12151

21 December 2012

**RESPONSE TO SUBMISSIONS - LATE SUBMISSION FROM TRANSPORT FOR NSW  
DUBBO BASE HOSPITAL REDEVELOPMENT - SSD DA (SSD 5250)**

1	19/12/12	Bus 12.5m Swept Path		KD	OK
Rev	Date	Description		Drawn	Appr:

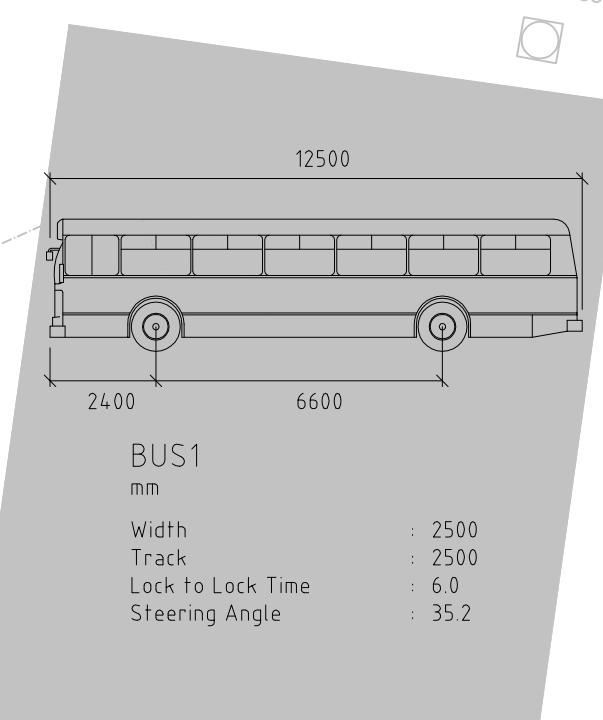
Transport for NSW has commented that it encourages an ongoing collaborative approach between Health Infrastructure and Dubbo City Council to deliver seamless infrastructure that ensures bus passengers and pedestrians can alight and be assured of safe and convenient access to the hospital grounds from bus stops on the Golden Highway.

To that end TfNSW has suggested two options for improving access and legibility for visitors to the Hospital that may arrive by bus.

1. Proposed Internal Roadway to cater for bus movements and pick-up / drop-off; or
2. External infrastructure improvements on the southern boundary and access to the Hospital off the Golden Highway.

- The internal roadways have insufficient width to accommodate the required bus movements into and out of the site.
- A preliminary swept path analysis of a 12.5 metre bus travelling along the potential loop has been undertaken and is shown in the attached plan. The plan assists in illustrating the potential issues raised above in terms of insufficient roadway width and conflict with emergency and pick-up / drop-off vehicles.

Cardno has provided a figure with bus swept paths to demonstrate the general constraints for manoeuvrability in this part of the Hospital Campus (refer Cardno's attached figure).
